Application Ref:	3/2021/0460	 Ribble Valley Borough Council www.ribblevalley.gov.uk
Date Inspected:		
Officer:	LE	
DELEGATED ITEM FILE REPORT:		Decision APPROVE

Development Description:	Proposed non-material amendment to planning approval 2020/0331 to allow the omission of a ground floor window on the north east elevation, rebuild garage but shorter in length and minor level changes. Amended plan received 27.5.21
Site Address/Location:	Former Filling Station 10 Sawley Road Chatburn BB7 4AS

North East Elevation

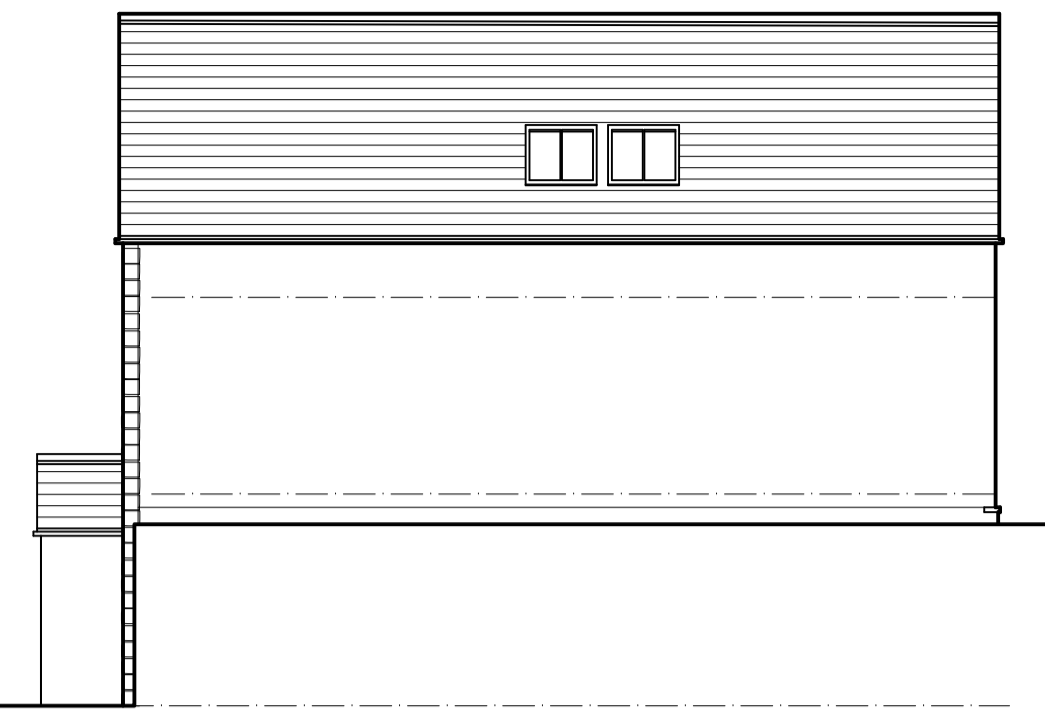
The omission of the window is considered minor enough to be considered a non-material amendment.

Garage Details

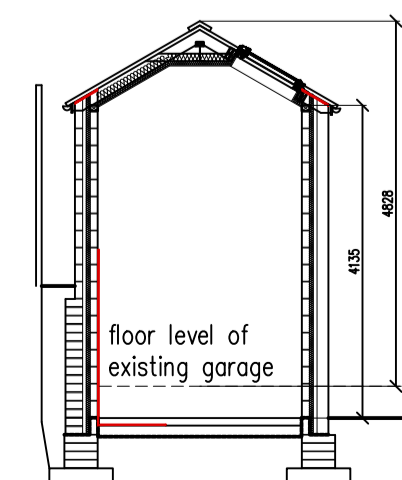
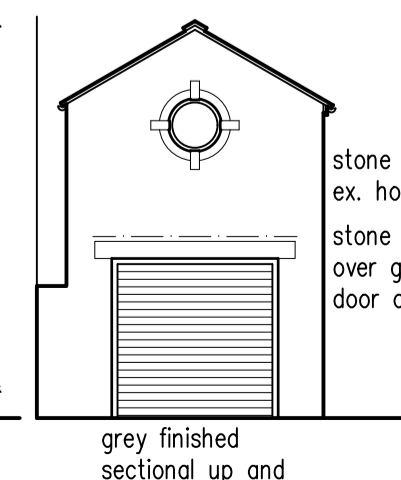
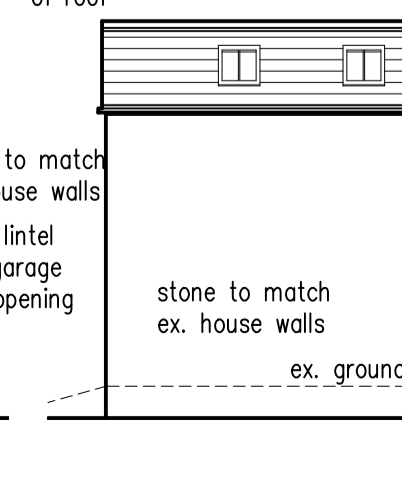
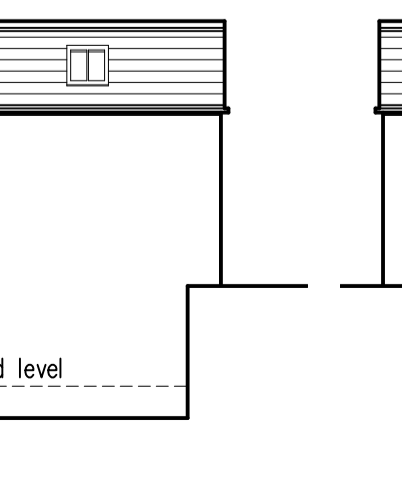
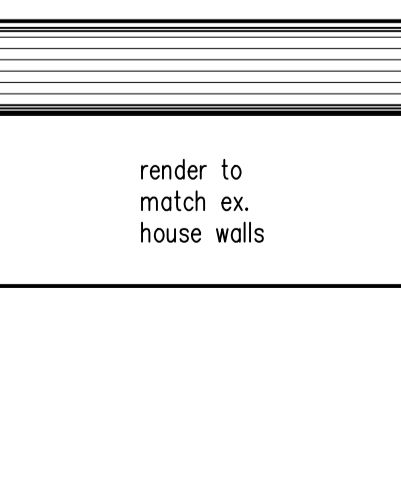
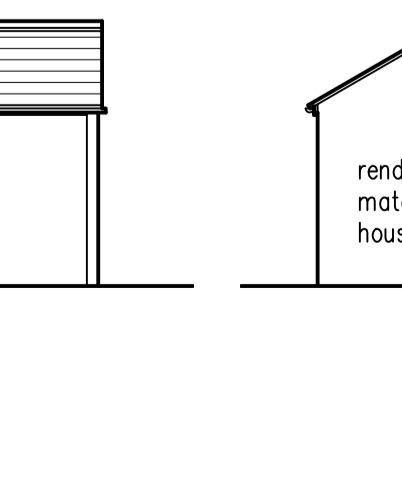
However, on inspection of the submission is it apparent that whilst the new build will occupy a smaller footprint the ground has been lowered by less than 50cm so that the overall height of the garage will be higher but the ridge will be a similar height to the old garage. The plans have been amended to omit a first floor within the garage. Conservation rooflights are also proposed and slight changes to fenestration. Overall the garage will appear a similar scale to the previous garage from most vantage points. On the basis of this it is not considered that the finished structure will appear materially different to the previously existing garage and is minor enough to be dealt with as a non-material amendment.

The resultant proposal as shown on the amended plans will not be materially different from that originally approved and therefore will constitute a non-material amendment to the original planning permission.
